**WELWYN HATFIELD BOROUGH COUNCIL  
EXECUTIVE DIRECTOR - PLANNING, PUBLIC PROTECTION AND GOVERNANCE**

**Application No:** 6/2022/0637/PN8  
**Location:** Coverack 50 The Ridgeway Cuffley Potters Bar EN6 4BA  
**Proposal:** Prior approval for an 8m rear extension from the kitchen and dining room to form a family room measuring 8 metres in depth and 3 metres to the eaves  
**Officer:** Mrs Kerrie Charles

**Recommendation:** Refused

Site address	50 The Ridgeway Cuffley EN6 4BA
Project Description	Rear Extension
Drawing Title	Existing Floor Plans & Elevations
Drawn	AA
Checked by	DP
Issued for	Planning Approval
Scale	1:100@A1
Drawing No.	1569_310
Date	March 2022

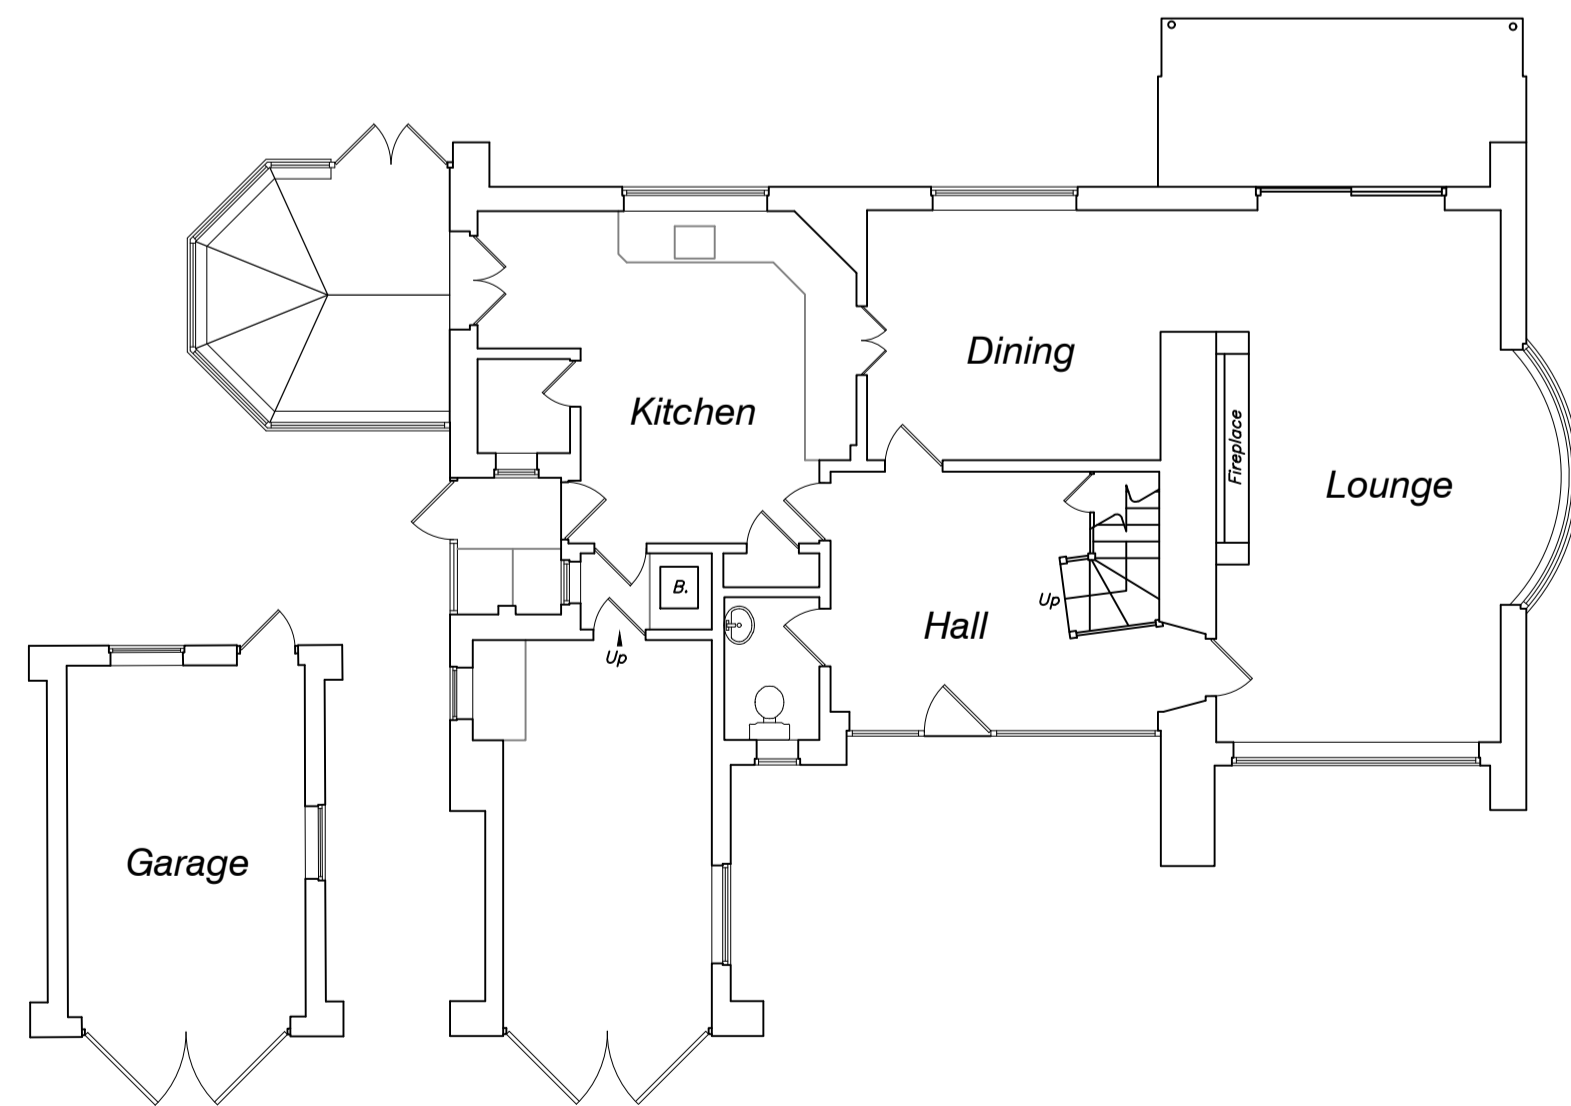
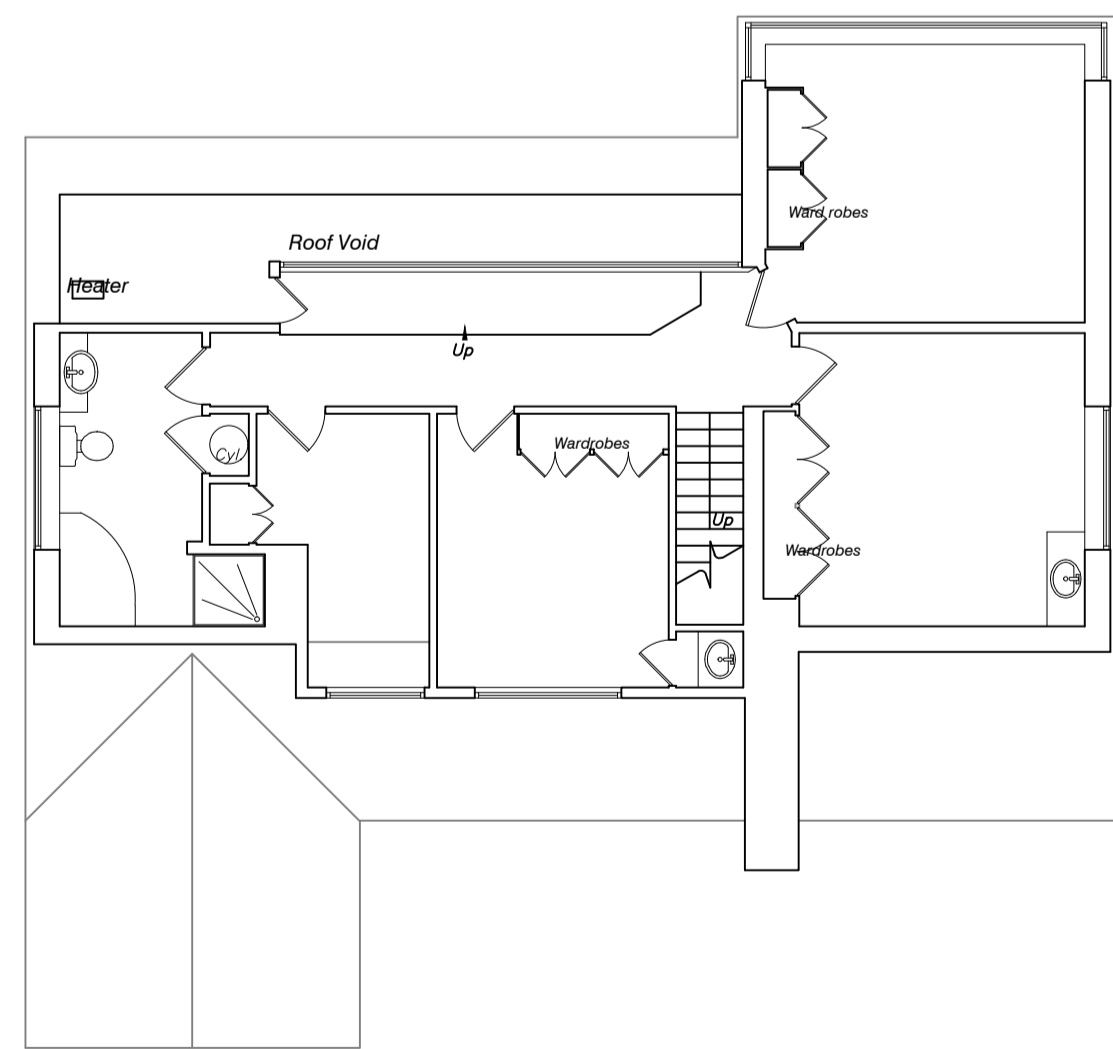
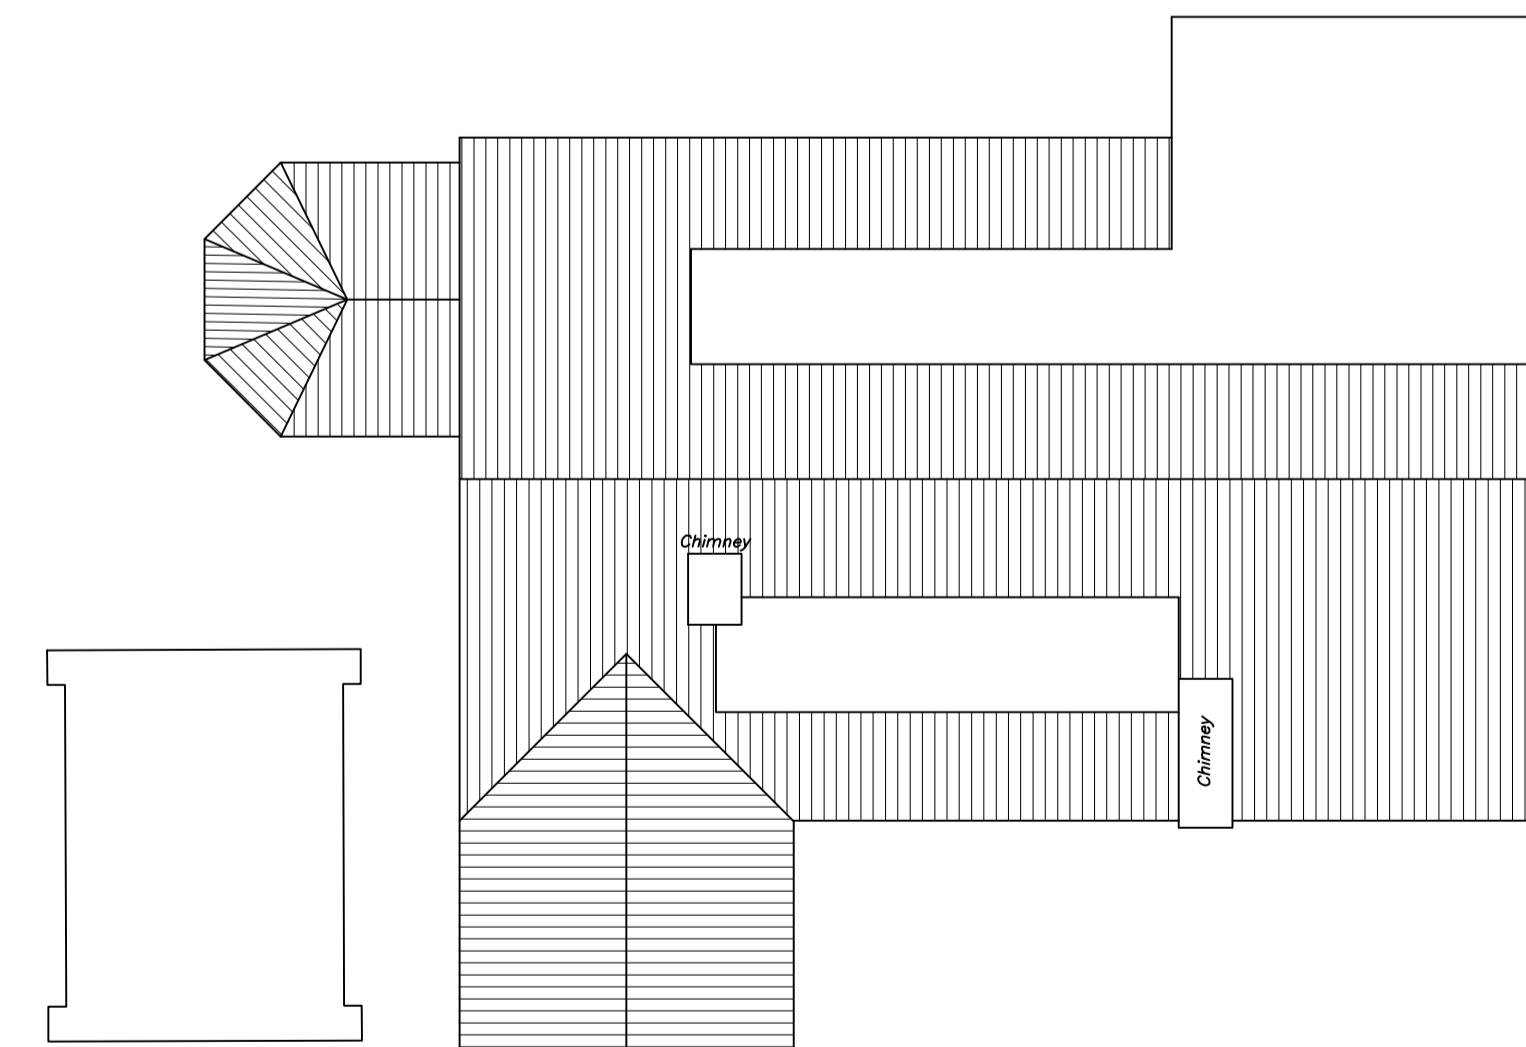
(g) is the development outside of article 2(3) land (conservation area) or outside of a site of special scientific interest	Y	Y
(g) cont_ would it have a single storey (previous extensions to the rear need to be taken into account)	<b>N - when joined to the existing first floor/roof extension</b>

(h) would the enlarged part of the dwellinghouse have more than one storey and:- (i) extend beyond the rear wall of the original dwellinghouse by more than 3 metres, or (ii) be within 7 metres of any boundary of the curtilage of the dwellinghouse being enlarged which is opposite the rear wall of that dwellinghouse;	<b>Y - when joined to the existing first floor/roof extension</b>	N

(j) would the enlarged part of the dwellinghouse extend beyond a wall forming a side elevation of the original dwellinghouse, and:- (i) exceed 4 metres in height, (ii) have more than one storey, or (iii) have a width greater than half the width of the original	Y	N

1. The proposed works is NOT permitted development by virtue of Schedule 2, Part 1, Class A of the Town and Country Planning (General Permitted Development) (England) Order 2015 as amended. The proposed extension would extend a first floor extension and would extend beyond a wall forming a side elevation, therefore fails to meet the requirements set under paragraphs A.1(f) and A.1(g) set out the limitations for single-storey extensions beyond the rear wall of the original dwelling/house and paragraph A.1(j) sets out the limitations for extensions beyond a wall forming a side elevation of the original dwelling/house. As the extension would have a width greater than half the width of

the original dwelling/house it would exceed the limitation on the width set out in clause (iii) of paragraph A.1(j).
